Comment for planning application 23/03428/OUT

Application Number	23/03428/OUT
Location	OS Parcel 7921 South Of Huscote Farm And North West Of County Boundary Daventry Road Banbury
Proposal	Outline planning application for the construction of up to 140,000 sqm of employment floorspace (use class B8) with ancillary offices and facilities and servicing and infrastructure including new site accesses. Internal roads and footpaths, landscaping including earthworks to create development platforms and bunds, drainage features and other associated works including demolition of the existing farmhouse
Case Officer	Chris Wentworth
Organisation Name	Michael Murray (on behalf of CPRE)
Address	22 Thornhill, Chacombe, Banbury, OX17 2JQ
Type of Comment	Objection
Type	neighbour
Comments	<p>CPRE CHERWELL DISTRICT COMMITTEE COMMENTS ON OUTLINE PLANNING APPLICATION 23/03428/OUT - OS PARCEL 7921 SOUTH OF HUSCOTE FARM AND NORTH WEST OF COUNTY BOUNDARY DAVENTRY ROAD BANBURY</p> <p>Introduction</p> <p>This application is essentially the same as the one previously submitted to the CDC in 2023 and which the developers, not wishing to delay adjudication to allow time for the necessary considered scrutiny leg

JOB TITLE		LAND AT M40 J11		CLIENT		GREYSTOKE	
DRAWING TITLE							
A361 ROUNDABOUT WITH SECONDARY ACCESS							
SCALE	DRAWN BY	DATE	DRAWING No	REVISION			
1:1000@A1	RM	04/12/23	23457-07-01GA	C

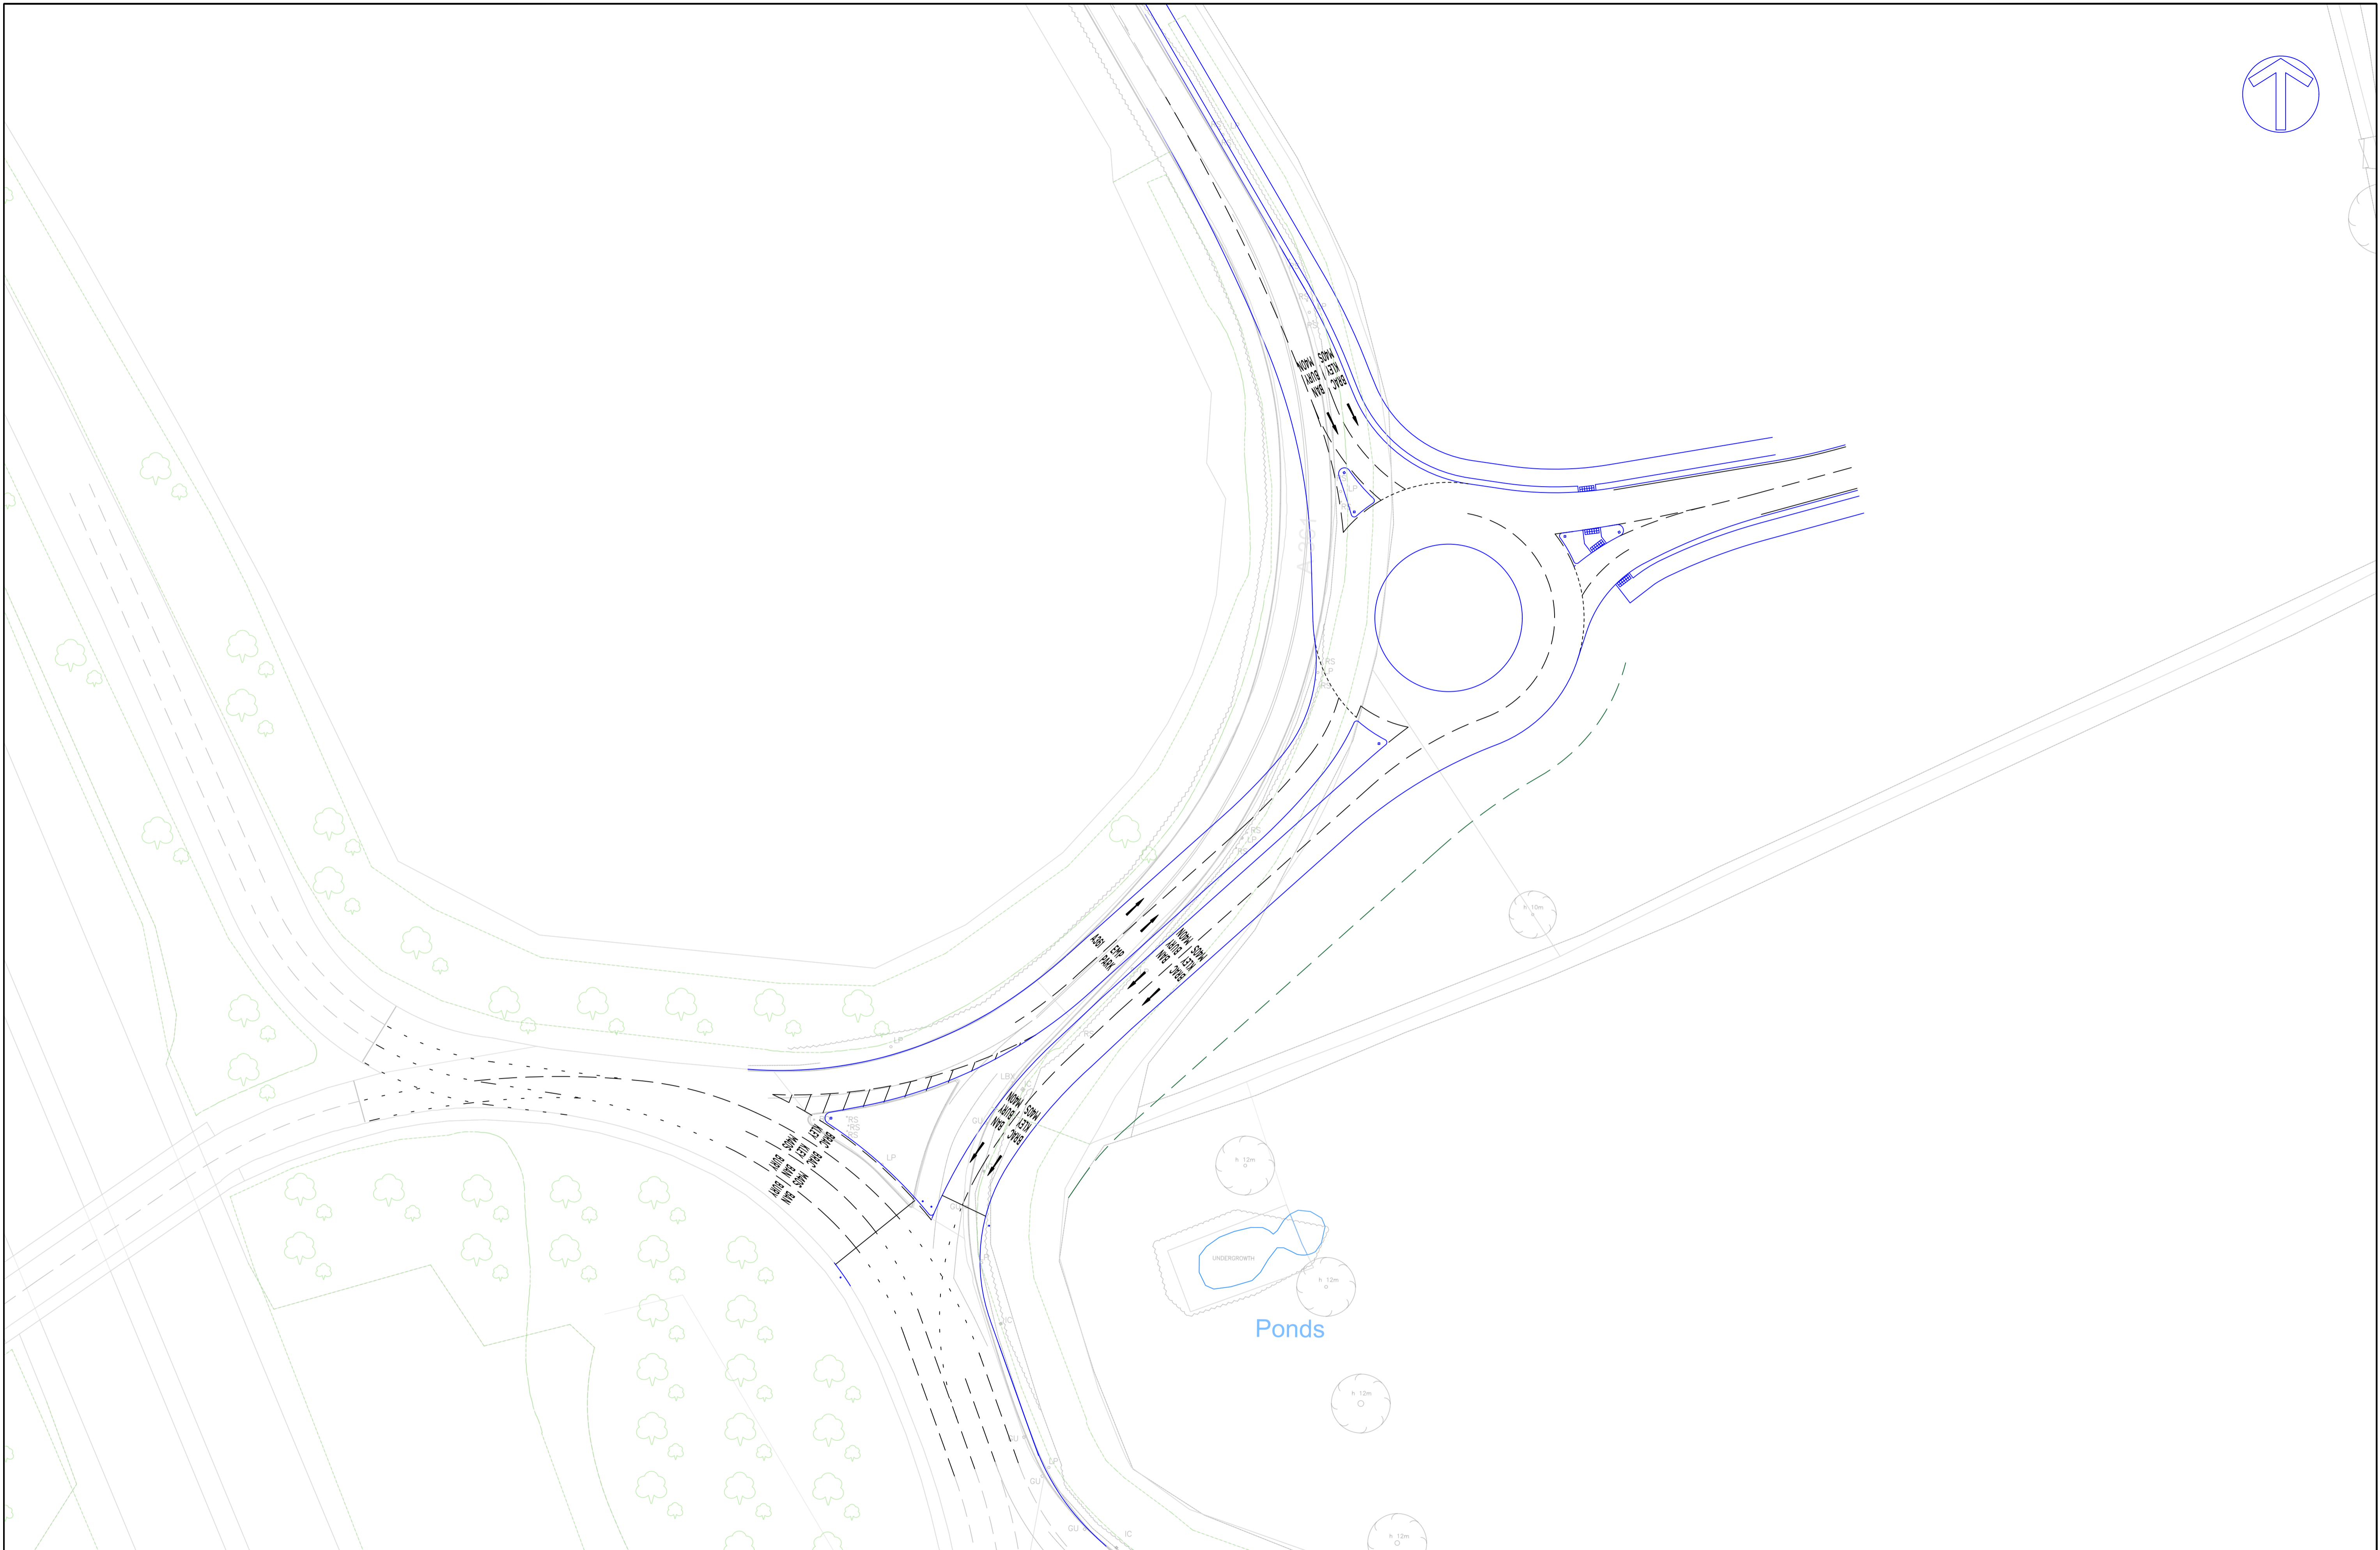
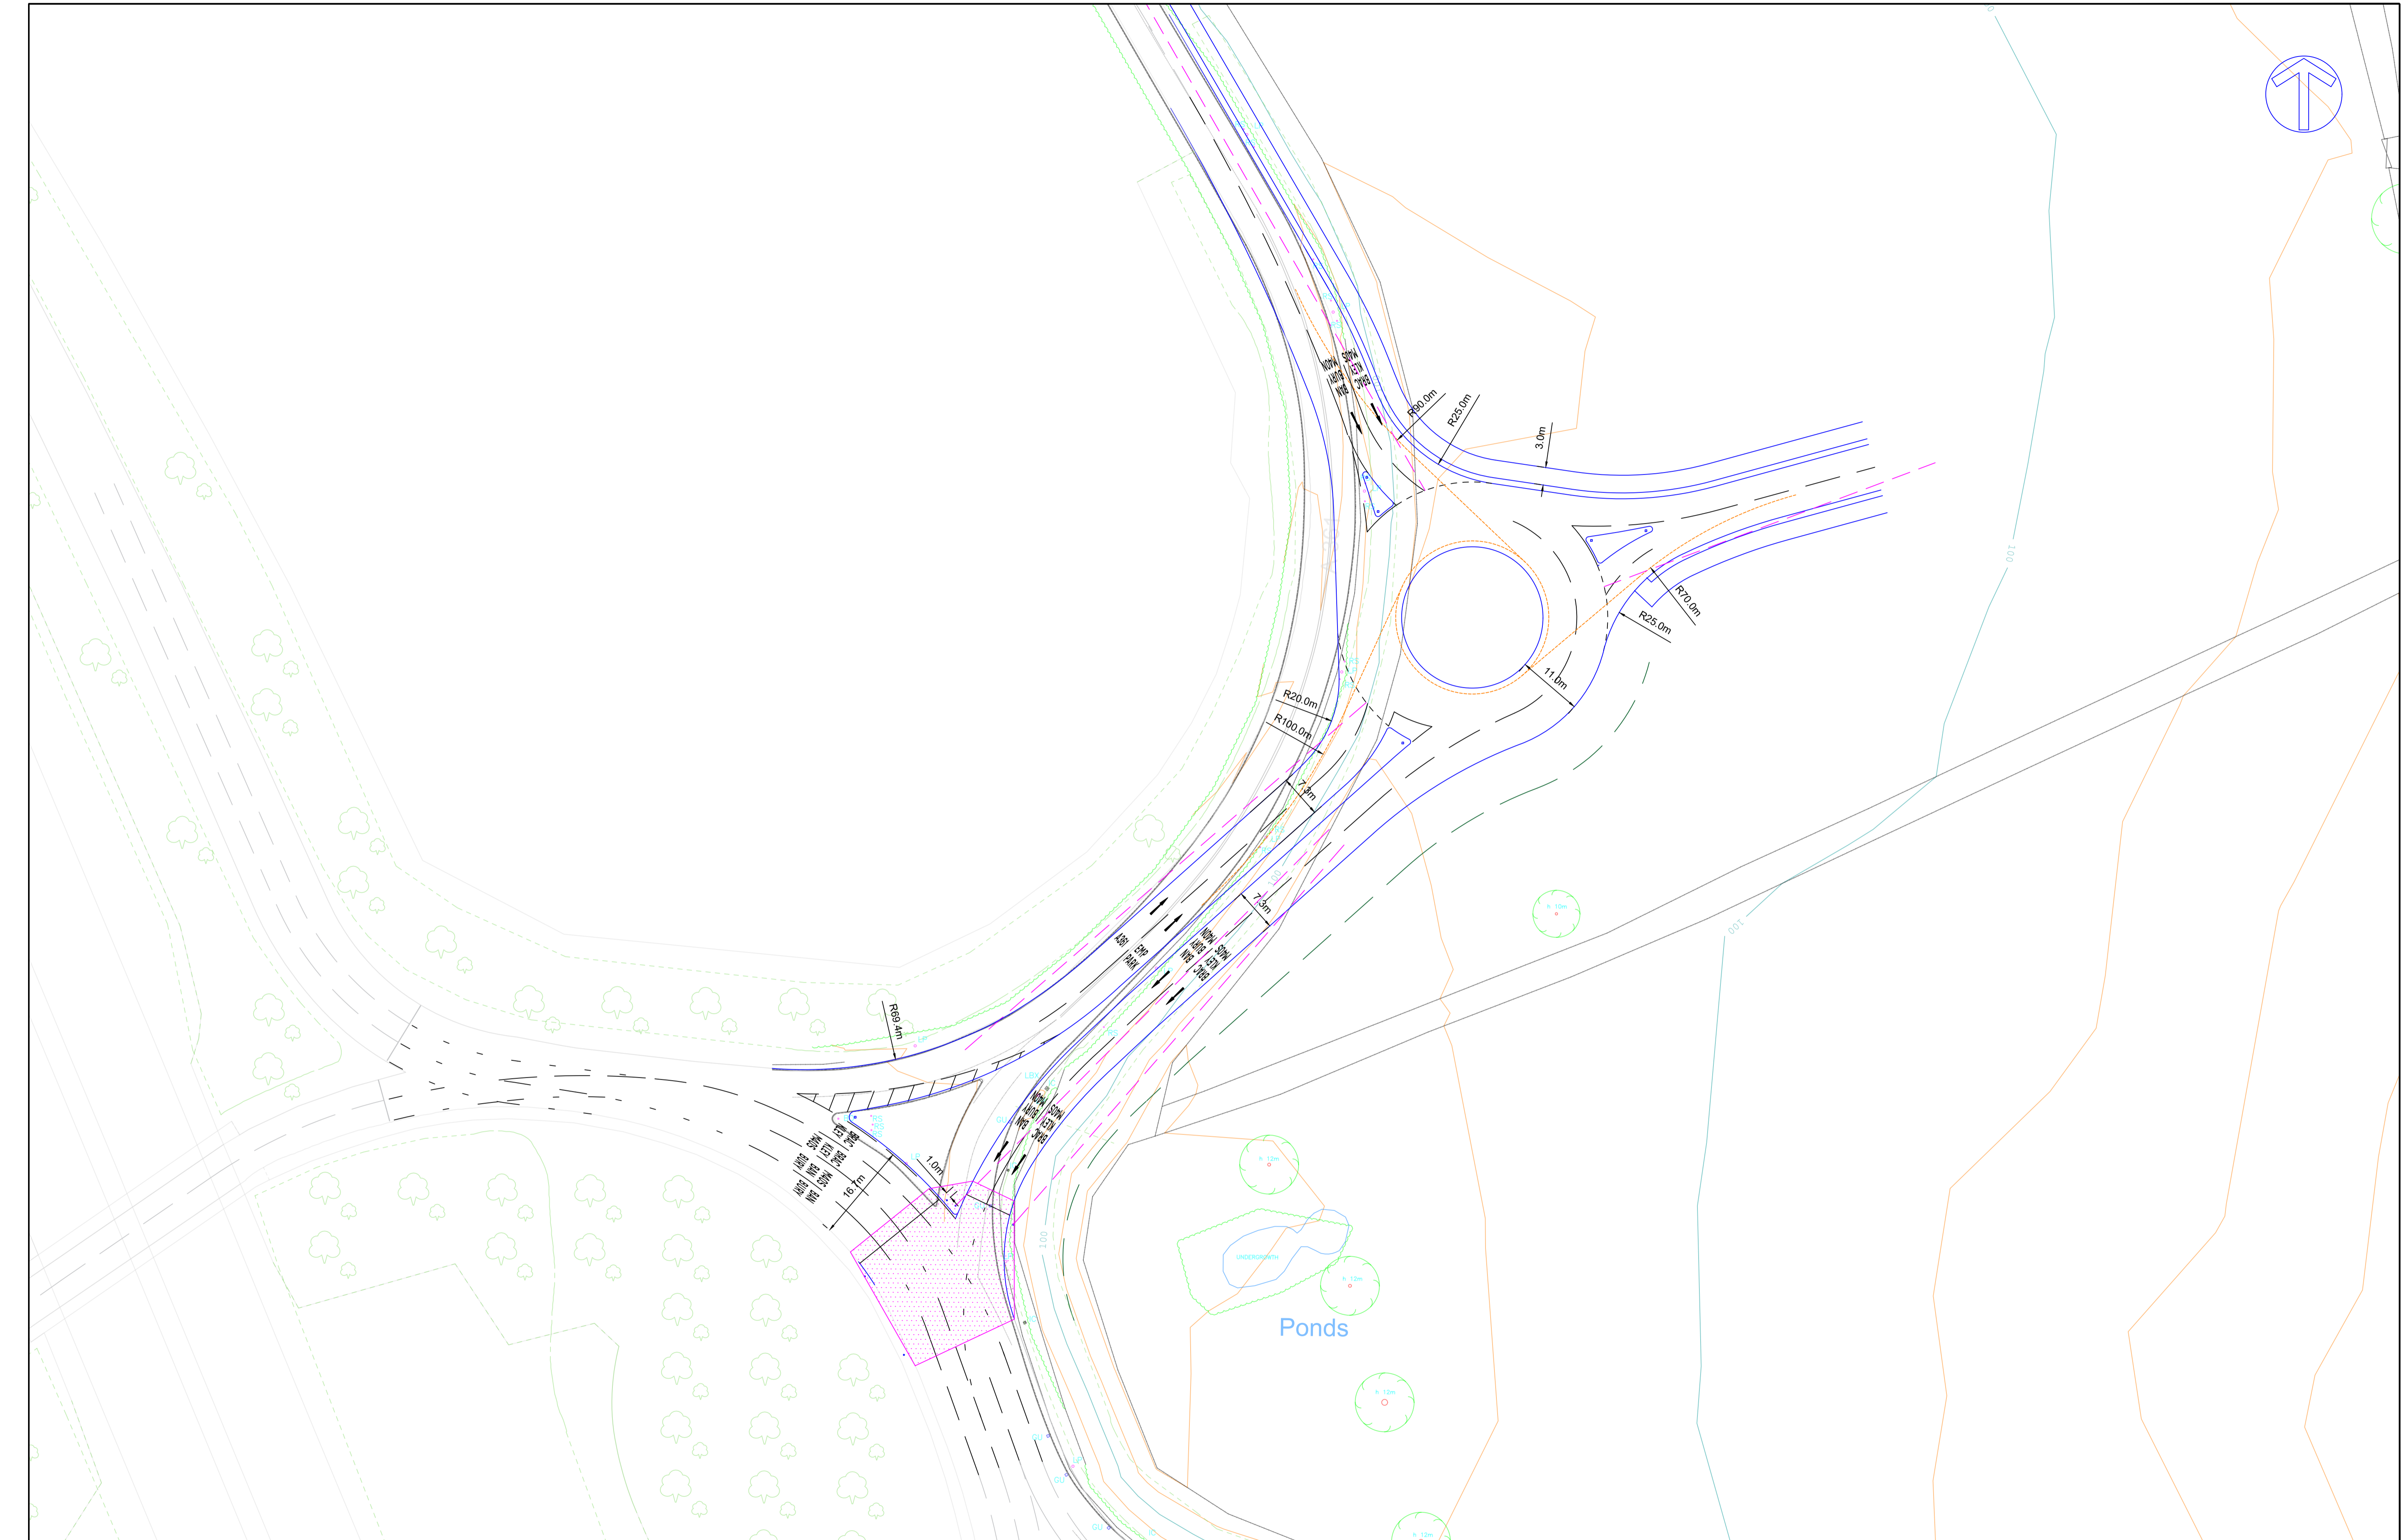
In their consideration of the original proposal, Oxfordshire County Council quite rightly suggested that the proximity of the proposed exit roundabout from the site at a distance of 100m from the J11 M40 interchange poses significant issues in terms of safety and traffic congestion at J11 and surrounding access roads. In conjunction with the extra traffic load anticipated from Frontier Park together with anticipated HS2 traffic, the extra traffic load in the vicinity of the already heavily overloaded J11 would be unsustainable.

1. The major access point to the A361 would be within 100m of the junction itself on a 90 degree curve.
2. Even without the wholly inappropriately sited roundabout there would be three entry and exit points to major warehouse sites within a few hundred yards of the J11 of the M40 with one, at this stage, proposed to be on a tight curve. This can only represent a significant safety hazard let alone the significant potential for traffic build up along that stretch of road. The consultants obviously did not formulate any of their arguments on a day when an incident has occurred within the vicinity of or on Junction 11 of the M40. Even now, relatively minor incidents can have a significant adverse effect on traffic movements in the Banbury area for several miles around J11. Given the proximity of entry/egress to/from the proposed development to J11, it is not unreasonable to anticipate that even an incident within the boundaries of the development could severely impact traffic flow in a wide area in and around Banbury and on the M40 itself.
